# **WOLLONGONG HOSPITAL**

**ACCESS REVIEW**

**Morris-Goding Accessibility Consulting**

7<sup>th</sup> September 2011

LEVEL 4 GENERAL ARRANGEMENT PLAN

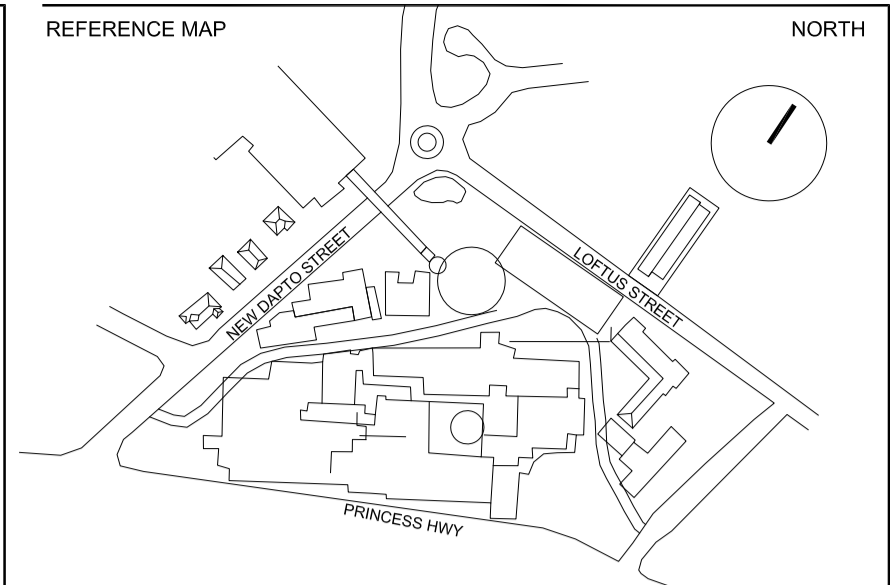
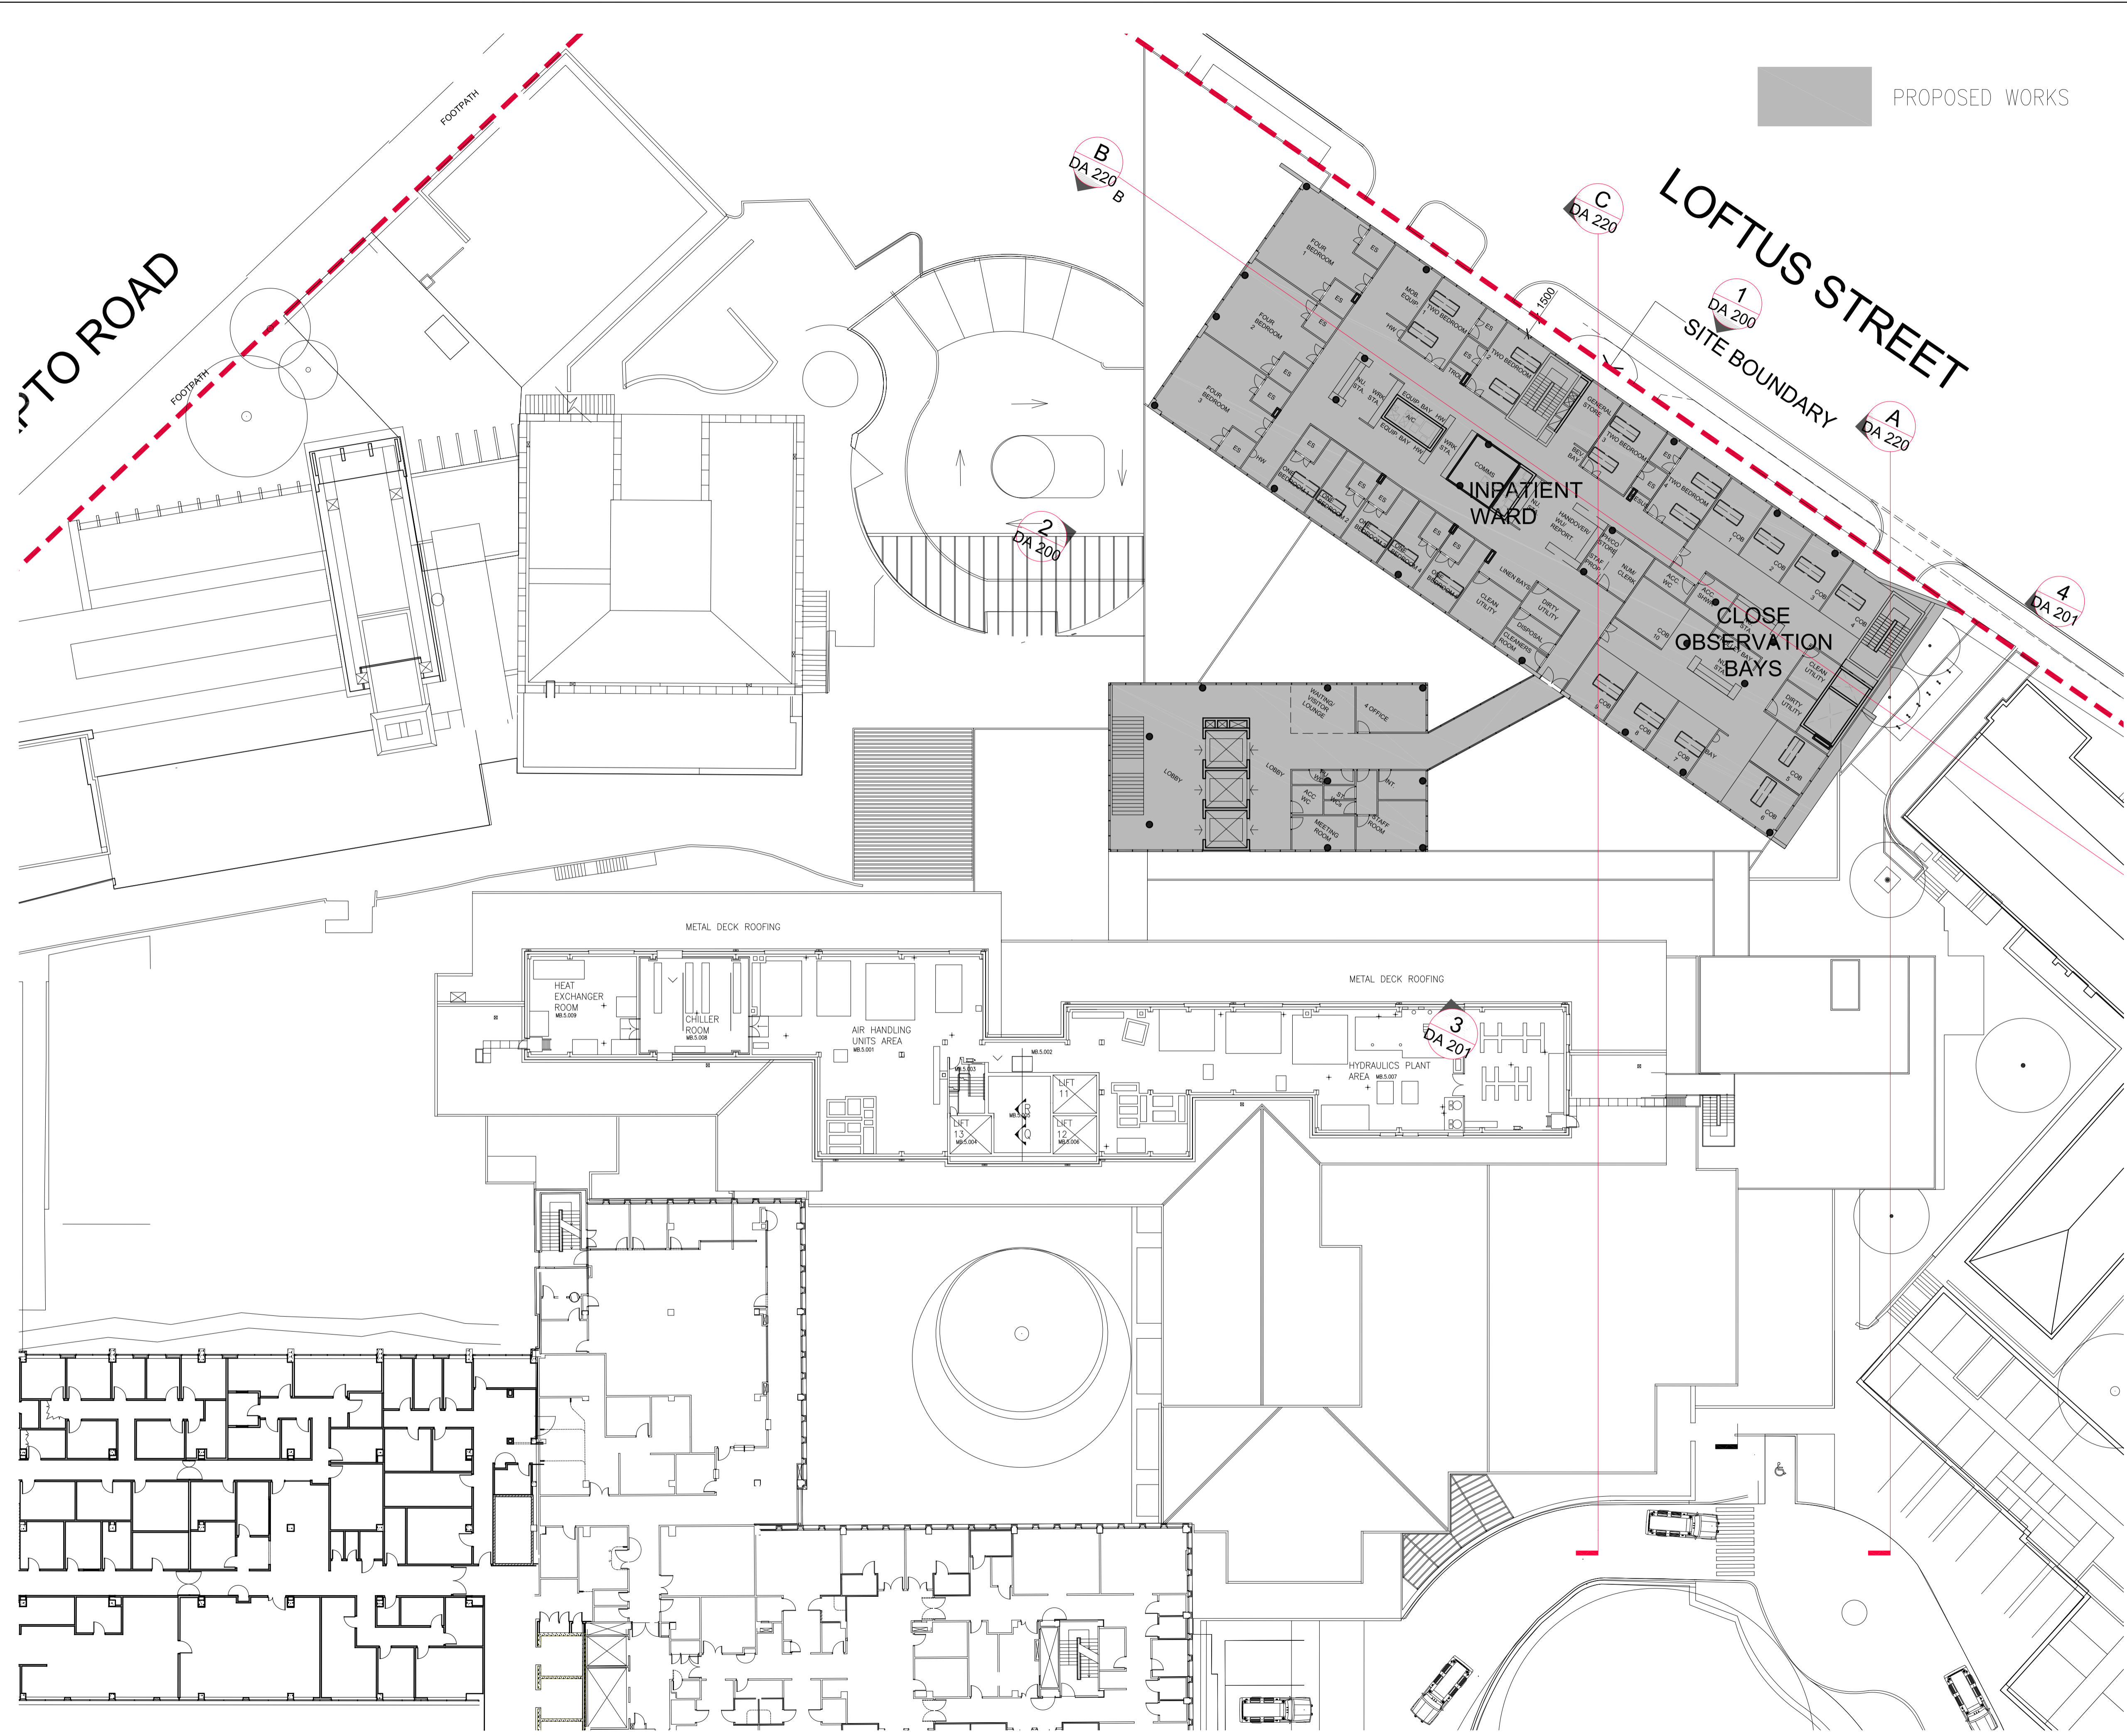
There are 2 unisex accessible WCs + 1 Accessible Change room found on the proposed new 1<sup>st</sup> and 2<sup>nd</sup> floor found within the (Peri Operative Department). In addition there is also a unisex accessible WC on the 4<sup>th</sup> floor nearest the lift lobby area. In general there are suitable accessible paths of travel leading to all accessible WCs from all corners on all floors.

In general, all proposed accessible WC have internal dimension that are (i.e. 2300mm x 1900mm) non-compliant with AS1428.1.

- (i) The accessible toilets throughout should have suitable pan locations that allow a mixture of left and right hand transfer.
- (ii) Currently, all public unisex accessible toilets need to be enlarged in accordance with AS1428.2. To comply, the internal dimension shall be at least 2700mm x 1900mm. This internal dimension will ensure a minimum unobstructed circulation space (2300mm x 1900mm) is achieved around the toilet pan.
- (iii) Provide an accessible WC near all banks of male and female toilets. Similarly the internal dimension shall be at least 2700mm x 1900mm. This internal dimension will ensure a minimum unobstructed circulation space (2300mm x 1900mm) is achieved around the toilet pan to comply with AS1428.1 and the DDA Premises Standards.
- (iv) Ensure bathroom fixtures comply with AS1428.1.
